**Application 3/2024/0726**

**Location: Shackletons Garden Centre Ltd, Clitheroe Road, Chatburn, BB7 4JY**

**Proposal: Proposed two-storey extension to rear and re-modelling of home and garden centre, including additional indoor and outdoor retail space and increased cafe area and play area**

I refer to the letter from the Lead Local Flood Authority dated 11<sup>th</sup> November 2024 in which the LLFA stated that they were unable to recommend the discharge of Condition 17 relating to surface water drainage. The LLFA gave the following three reasons (in italics below) and our comments are included below each reason given.

Title: PROPOSED DRAINAGE GENERAL ARRANGEMENT SHEET 1 OF 2

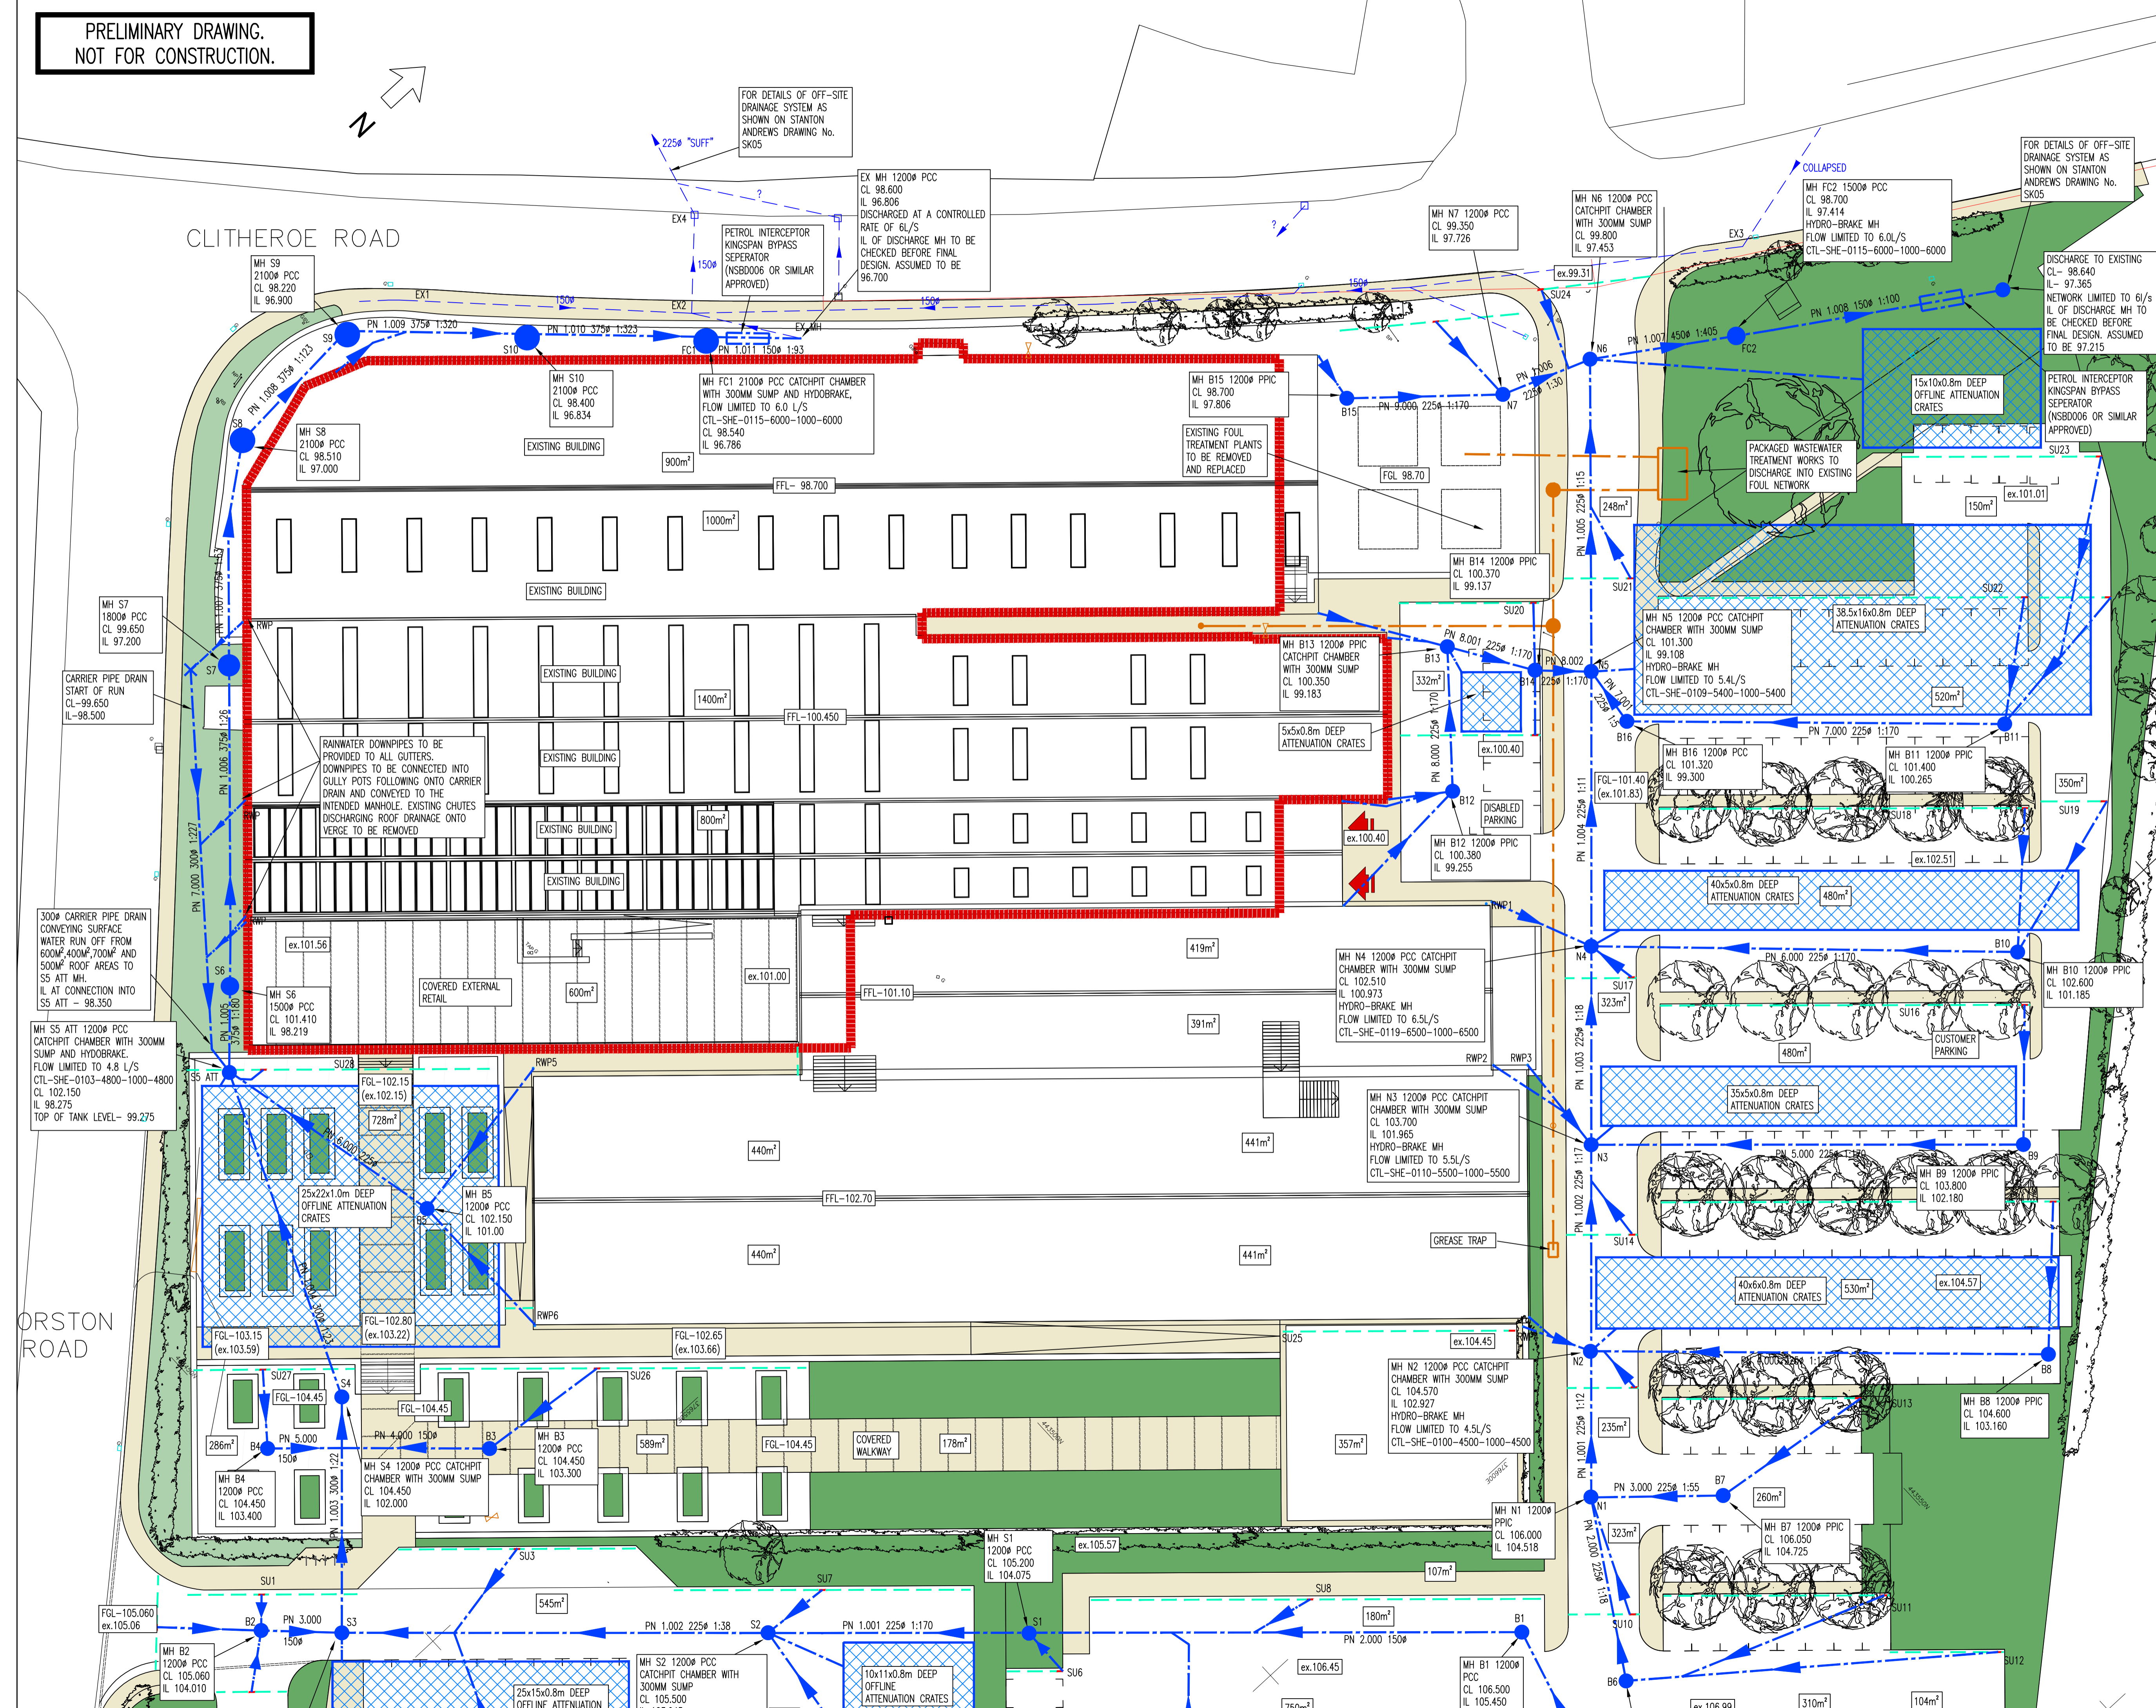
2. *The applicant has failed to provide evidence of Finished Floor Levels (FFL) in AOD with adjacent ground levels for all sides of each building to confirm minimum 150mm+ difference for FFL.*

The steep slope of the site necessitates the use of earth-retaining external walls in certain areas. However, wherever feasible, the ground floors of the proposed extensions are designed to be 150mm above the external ground level. This ensures compliance with design standards while adapting to site conditions.

Details of the retaining walls, proposed floor levels, and adjacent ground levels are clearly illustrated in the attached drawings 10301/101/P7 and 10301/102/P4.

Title:
SURFACE WATER EXCEEDANCE ROUTES

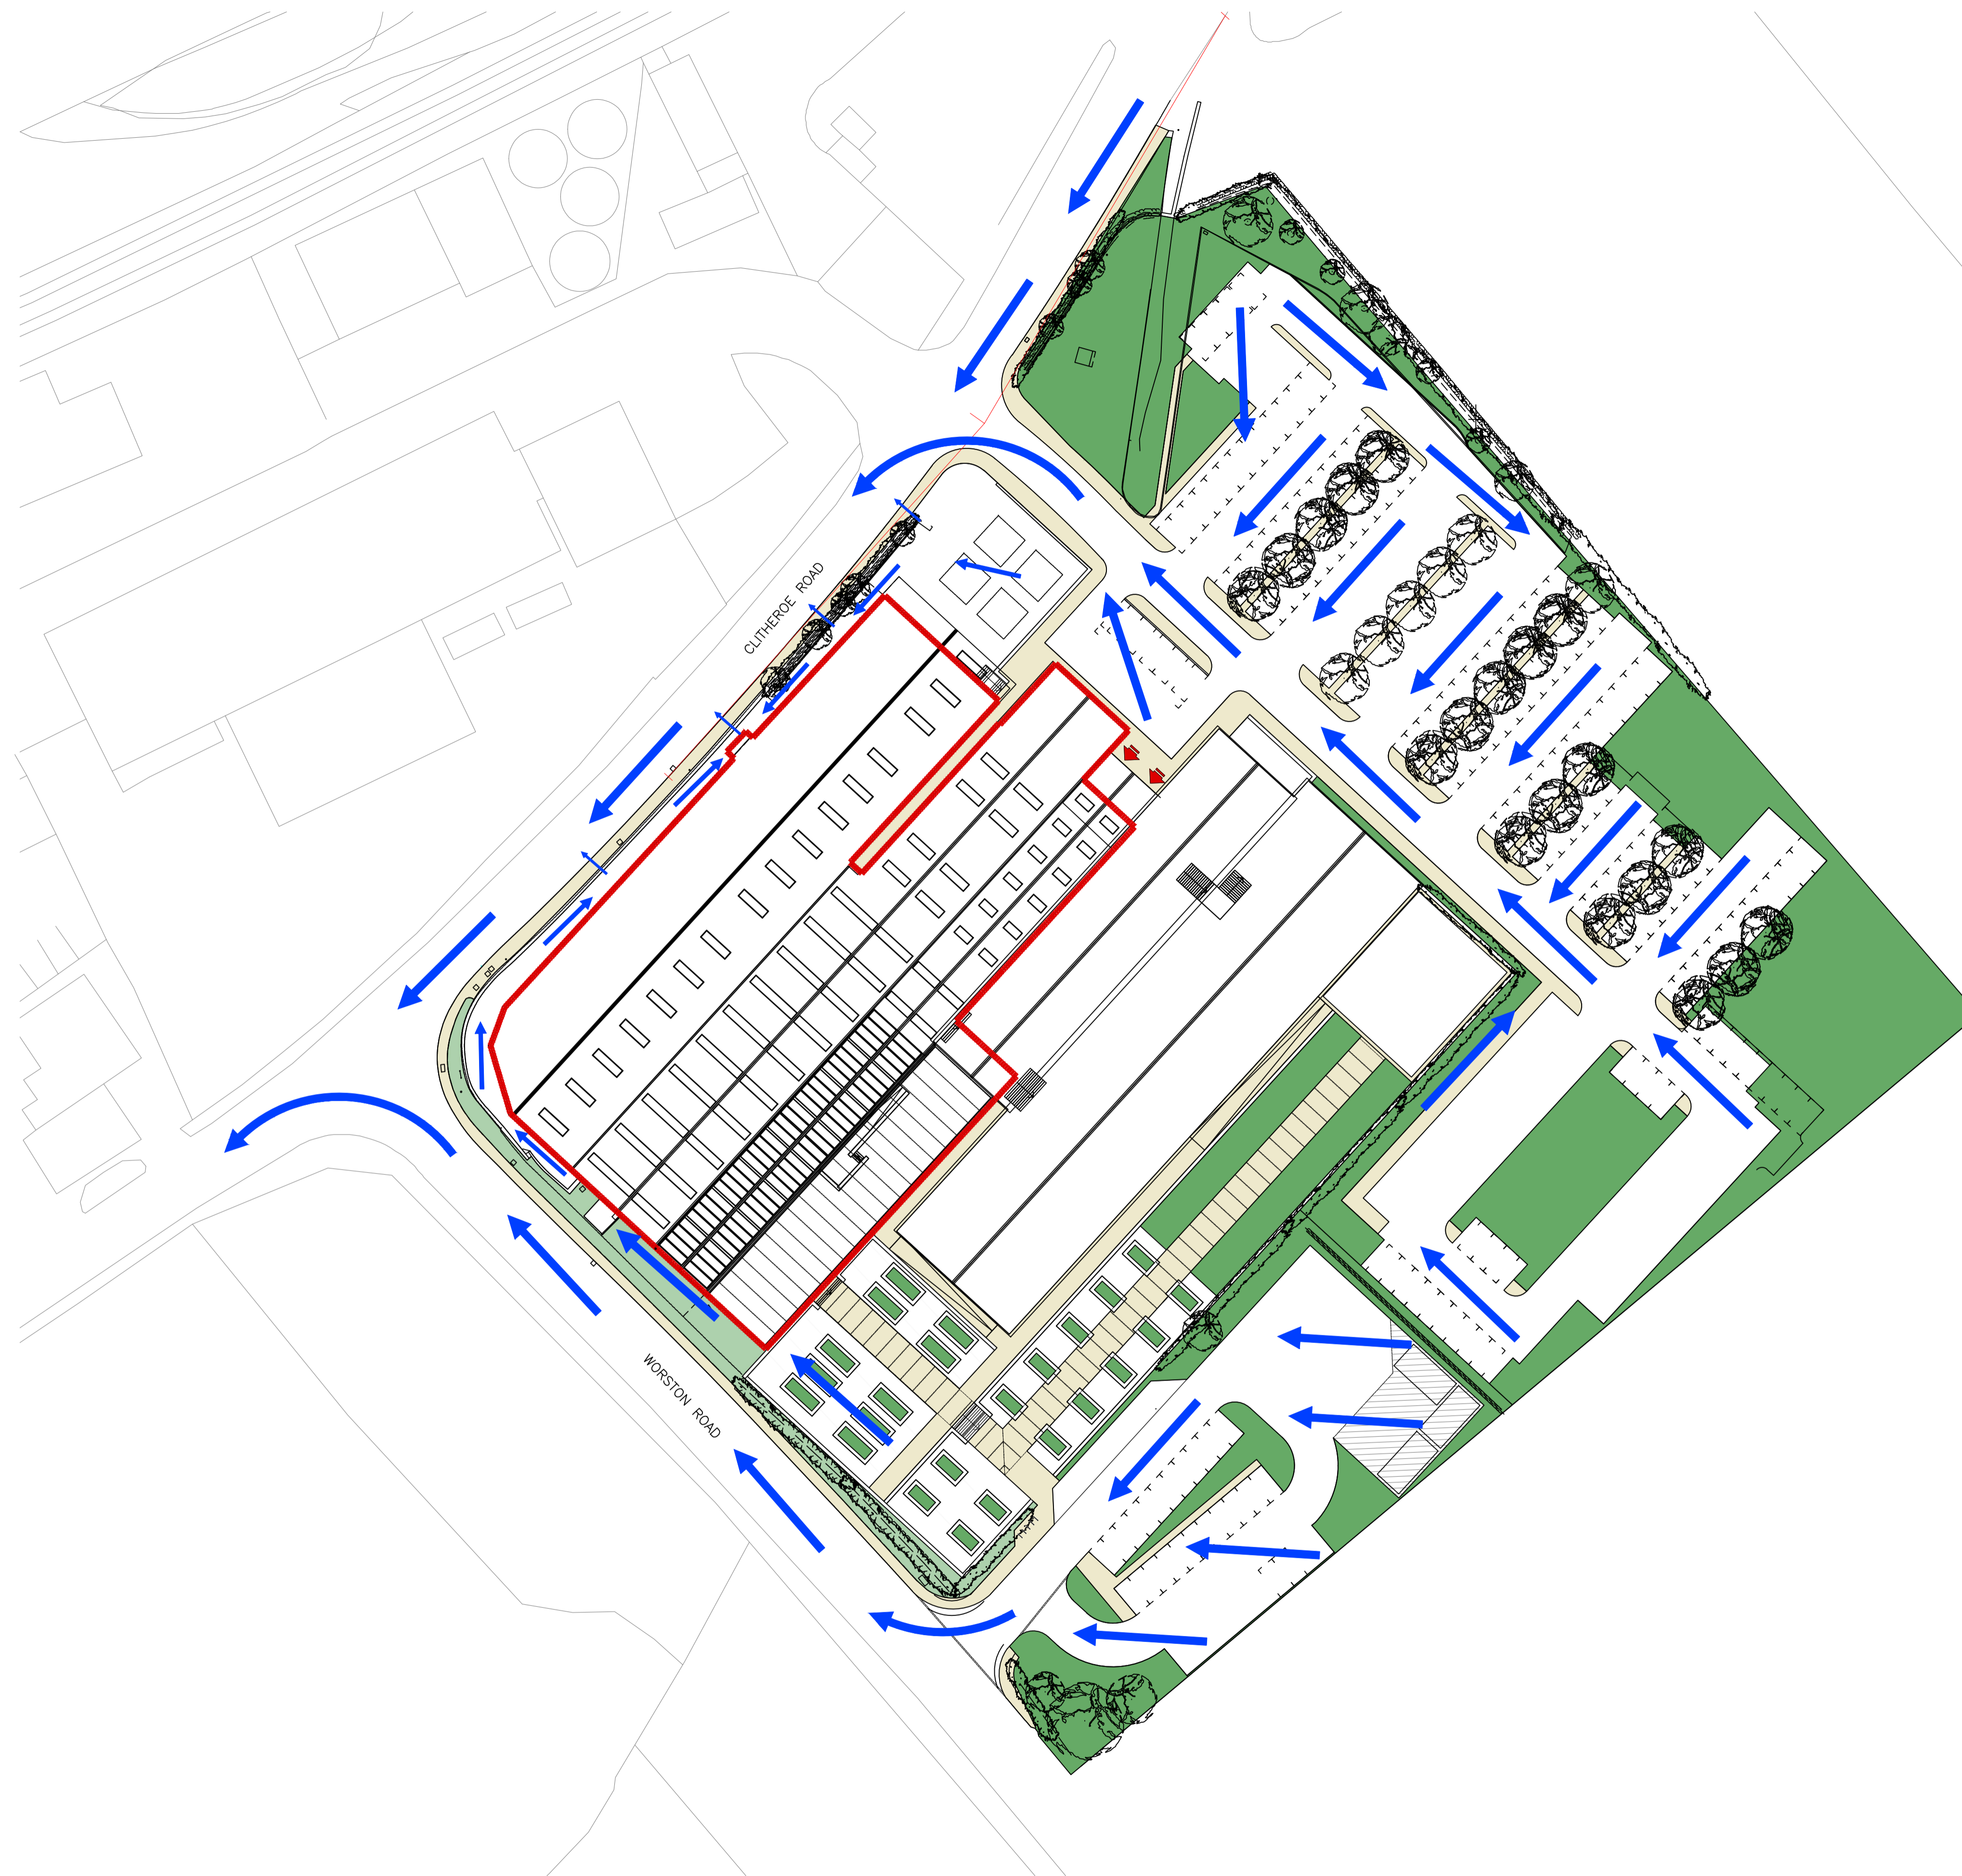
1. *The applicant has failed to provide evidence of flood water exceedance routes in accordance with Defra Technical Standards for Sustainable Drainage Systems.*

Exceedance flows from the site will be onto and along Clitheroe Road to the southwest. Exceedance flows were included in the previous correspondence Ref: 10301/sjr/01. To satisfy the above reason again the exceedance routes are included on the enclosed drawing 10301/106/P1.
